THE SHOP'S AT MERIDIAN RANCH

FILING NO. 1A, LOT 2

LANDSCAPE PLAN

EL PASO COUNTY, COLORADO.
FALCON, COLORADO

DRAWING NO.
2
LANDSCAPE PLAN

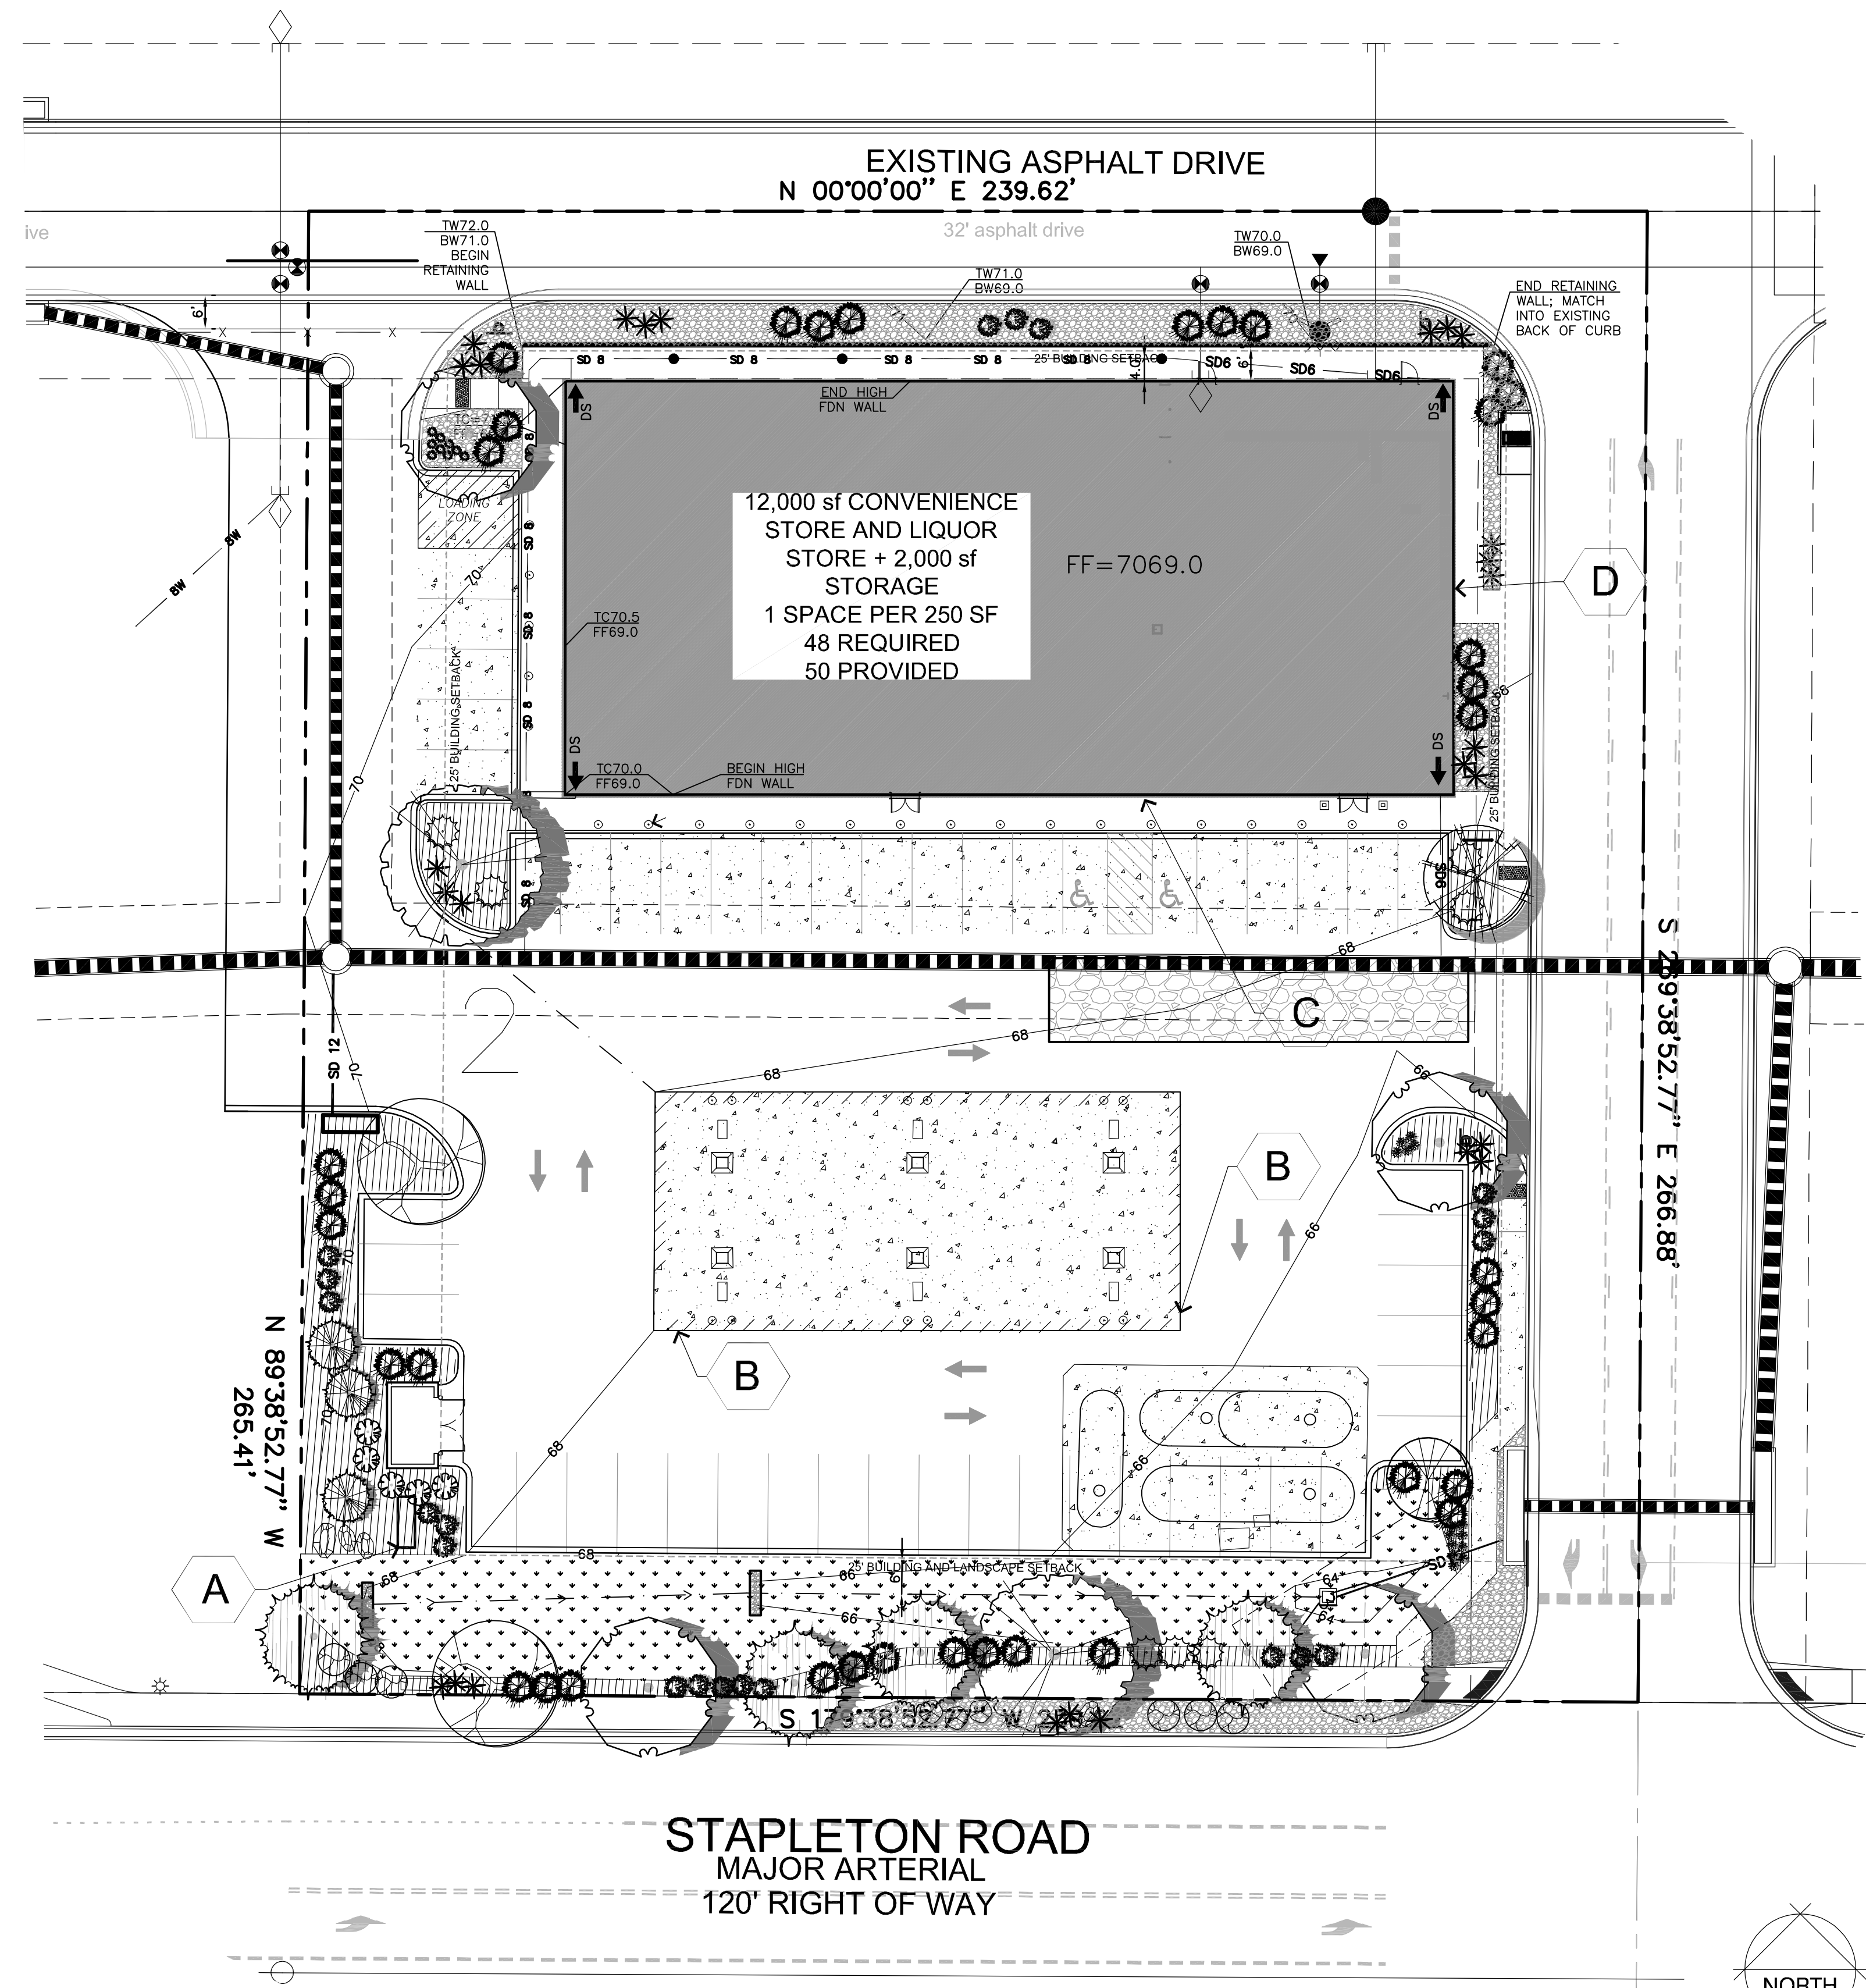
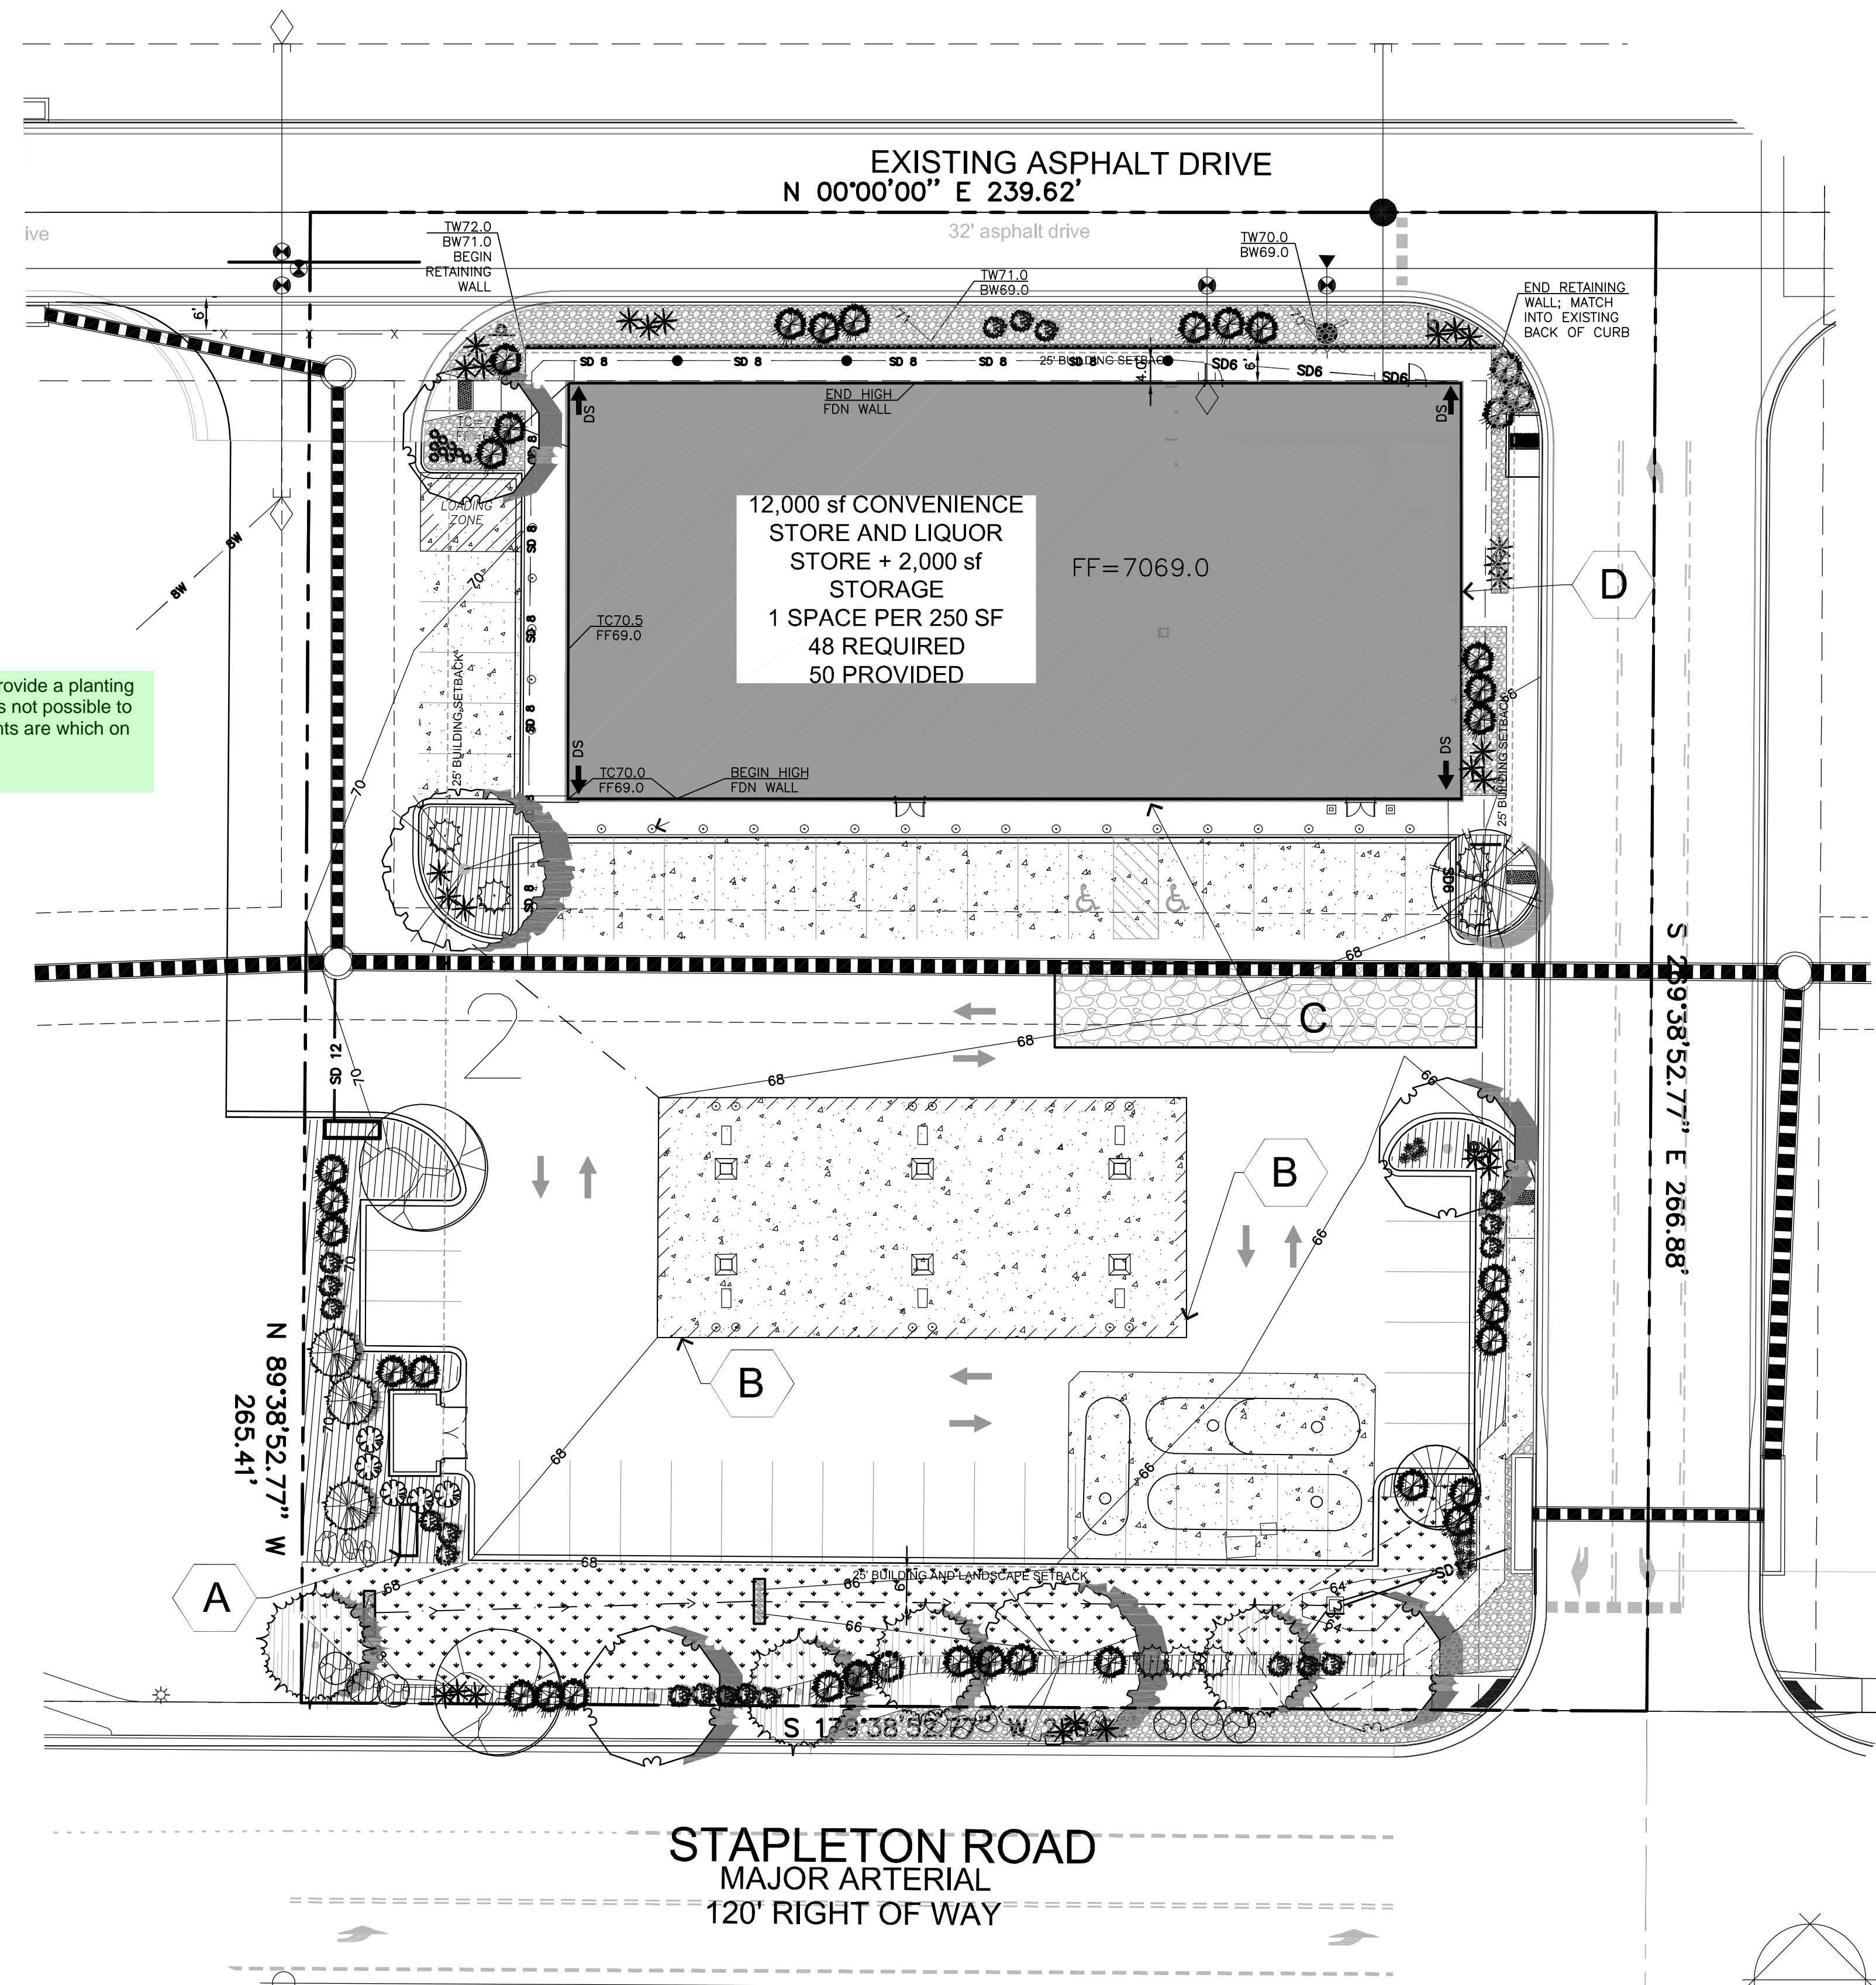
No Conflicts with Traffic or Sight Distance
Landscaping shall not conflict with traffic. Sight distance shall be maintained in accordance with the requirements of Chapter 2 of the ECM.

No Interference with Utilities and Fire Equipment. Landscaping shall not interfere with the general function, safety or acceptability of any gas, electric, water, sewer, telephone, or other utility easement or conflict with criteria established or adopted by a fire department.

Landscaping shall not exceed 8 inches in height within 3 feet of a fire hydrant or other applicable fire department criteria.

Landscape planting summary table to include a summary of required and proposed landscaping based upon adjacent or internal roadways, adjacent land use(s), parking area(s), buffer and screen area(s), and compliance with all internal landscaping requirements.

Please include on the landscaping plan location of Utilities/ fire Hydrants.

Landscaping is required between lot and curb / Loading docks and Other Vehicle Area Screened
There needs to be a buffer / screen on the rear side of this building
Identify the material type for a unnatural screen ie height / material etc

Show and label right-of-way lines. Trees are not allowed in county right-of-way nor objects greater than 18 inches in height.

OWNER INFO
company name SHOPS AT MERIDIAN RANCH LLC
address P.O. BOX 80036
SAN DIEGO CA 91238
phone number
Please update file number to "PCD File No. PPR2322"
